25. 07. 2011

**Planning Application for permission to erect a 4 Bedroom Bungalow
At 52 High Street, Bolton upon Dearne, Rotherham
As replacement of earthquake damaged Bungalow
Your Ref 2011 0812**

GENERAL ARRANGEMENT PLAN DRWG. NO. 722/2R

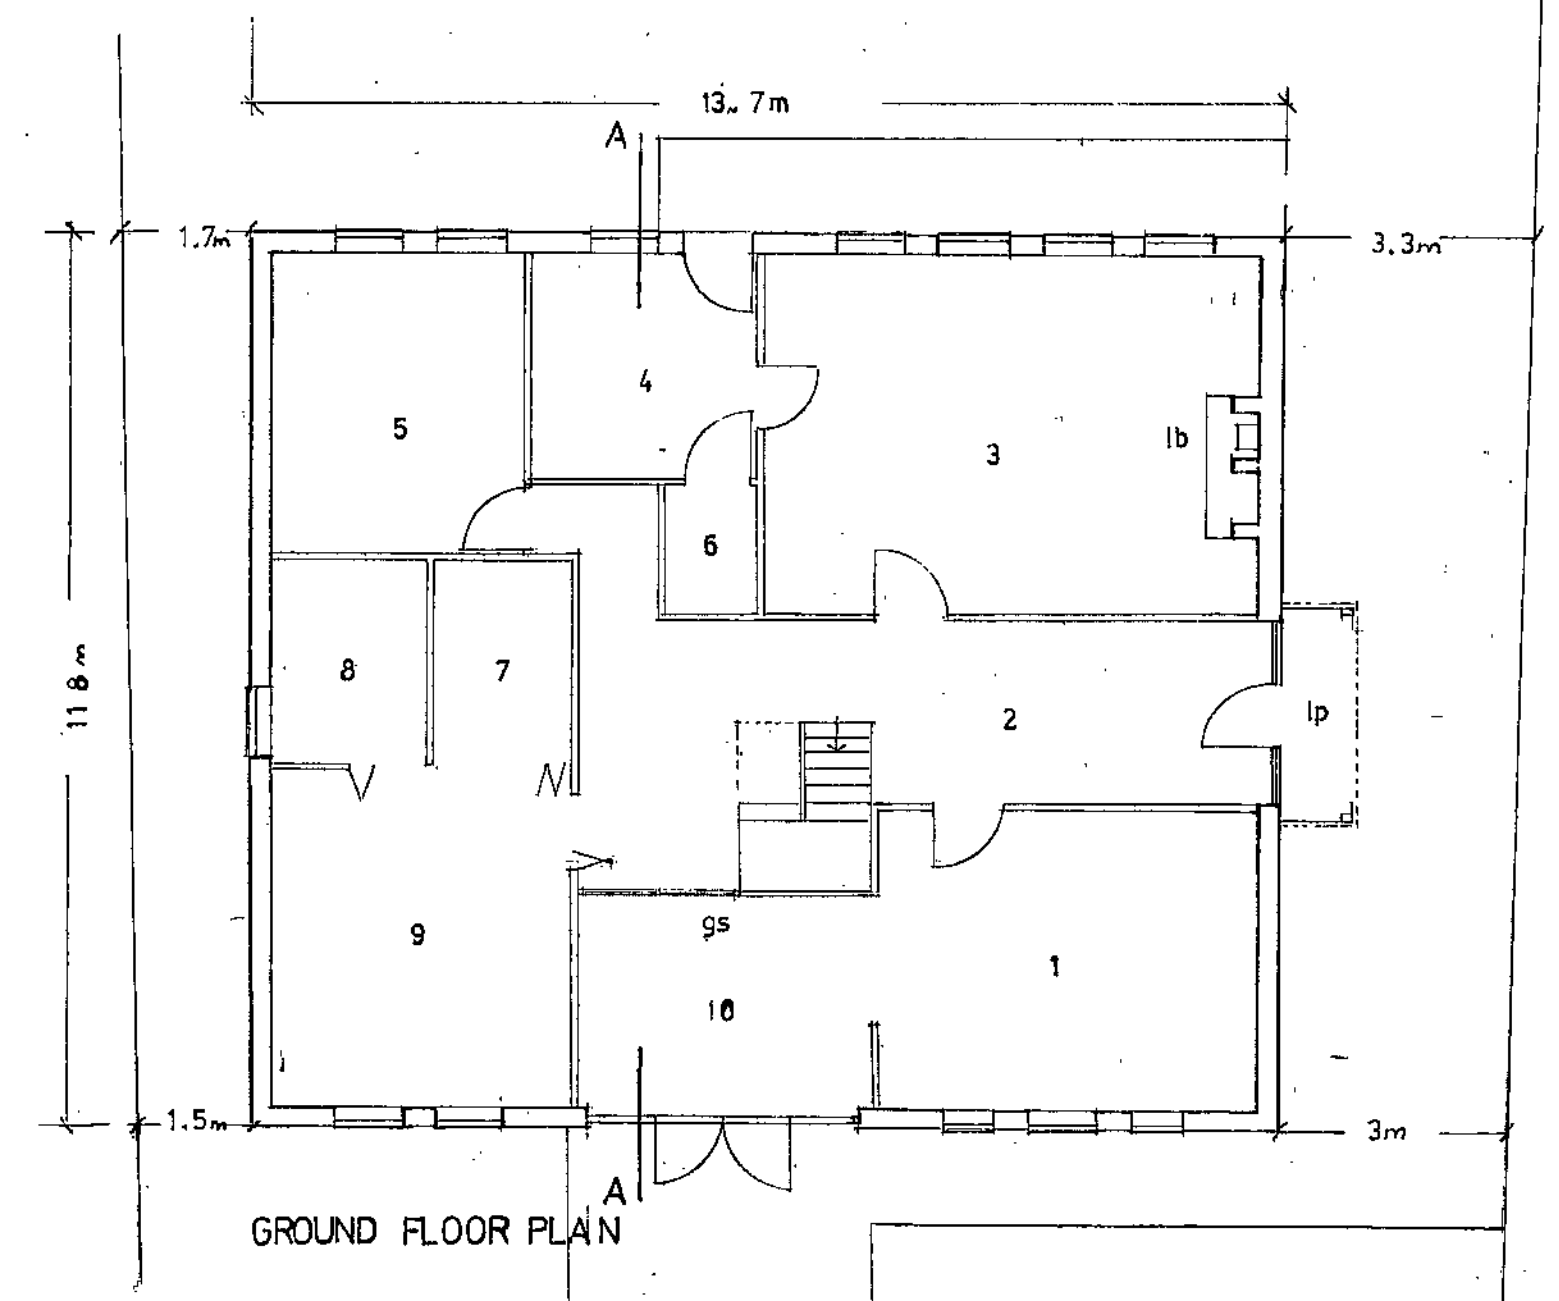
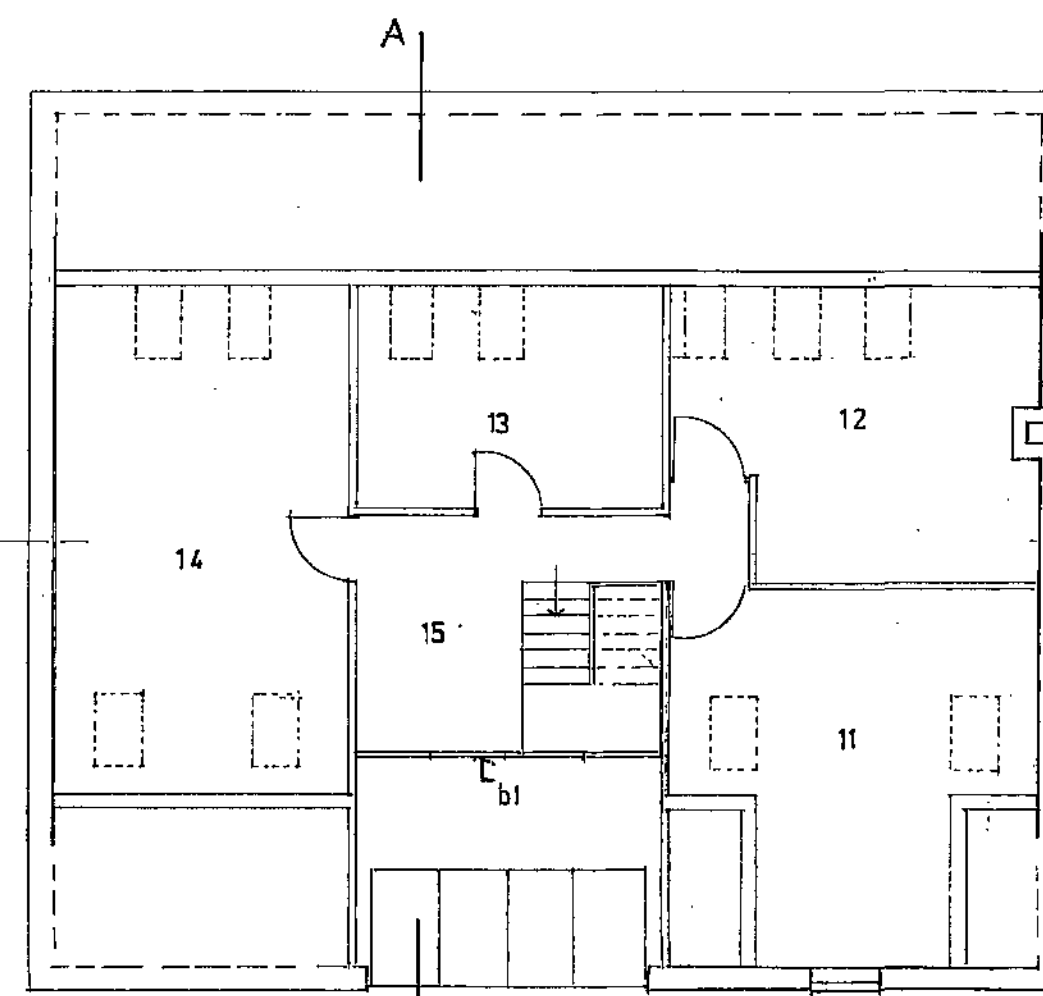
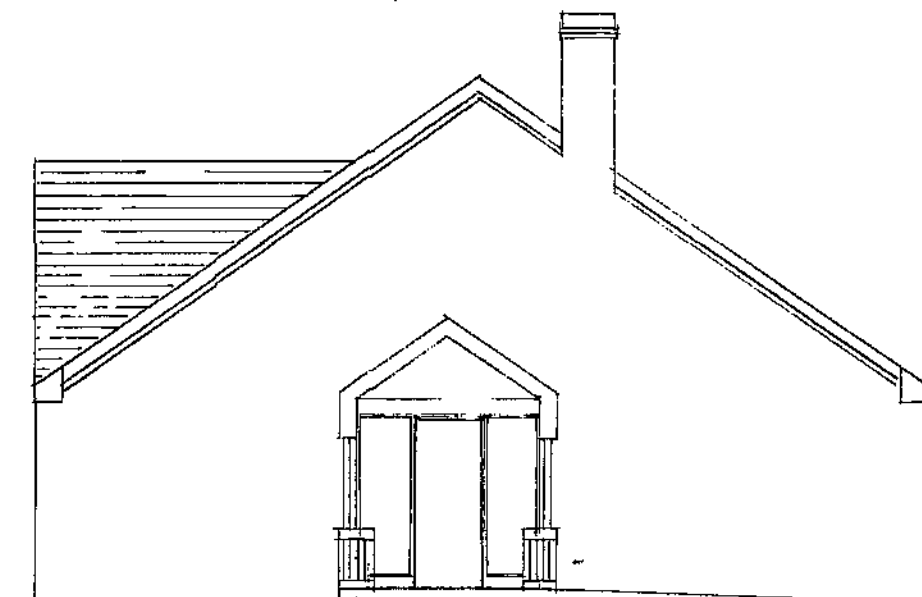
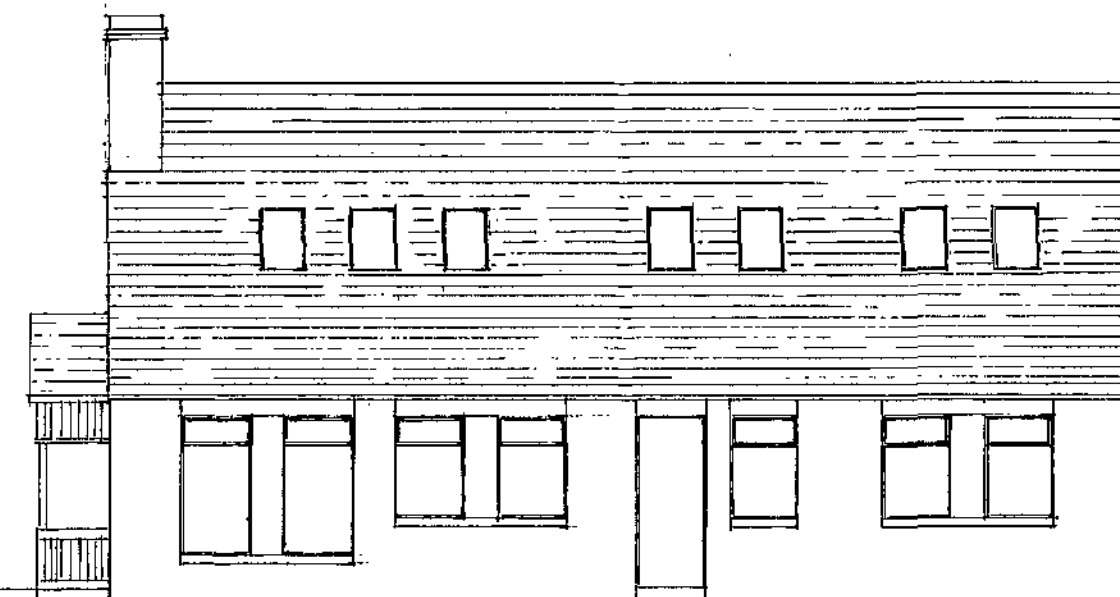
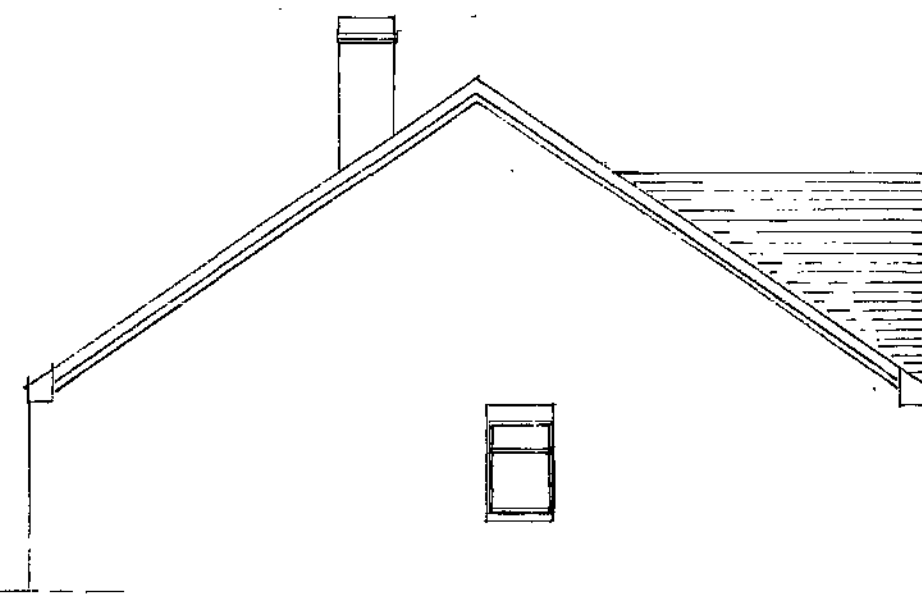
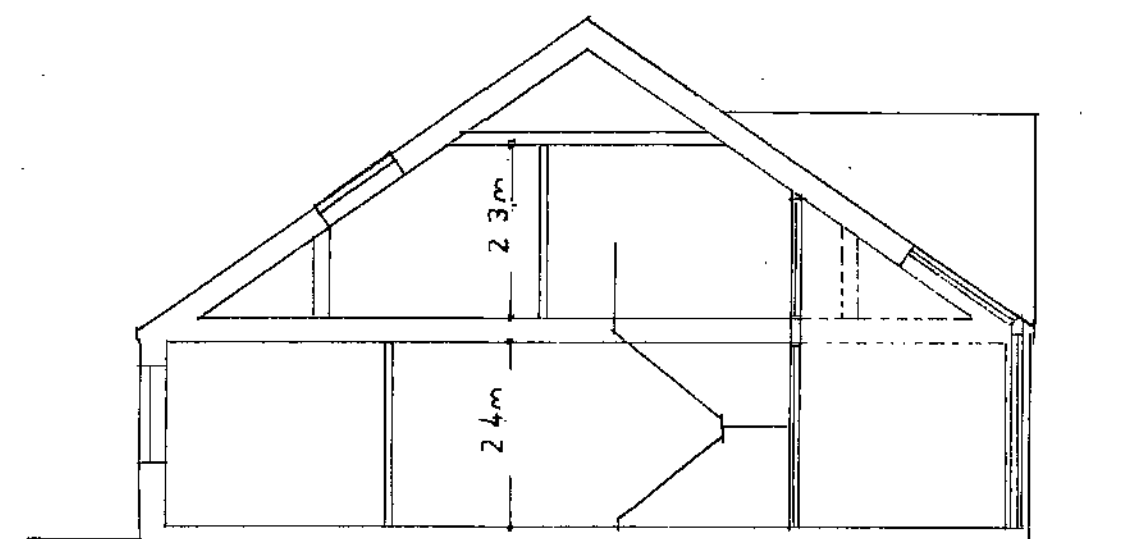
Following your communication to me of the 14th inst. I discussed the issues you raised with Mr & Mrs Empringham, We came to the conclusion the main issue raised about the proximity of the proposal to No. 50 High Street could in some measure be overcome by flipping the design. Whilst this in itself would not entirely meet the criteria you set out a reduction in frontage of 0.5m. is also proposed which could ensure an appropriate siting of this bungalow design between the adjacent houses of No. 50 High Street and 43 Ingsfield Lane

Please find herewith 2 copies of drawings 722/1R & 2R showing the revisions
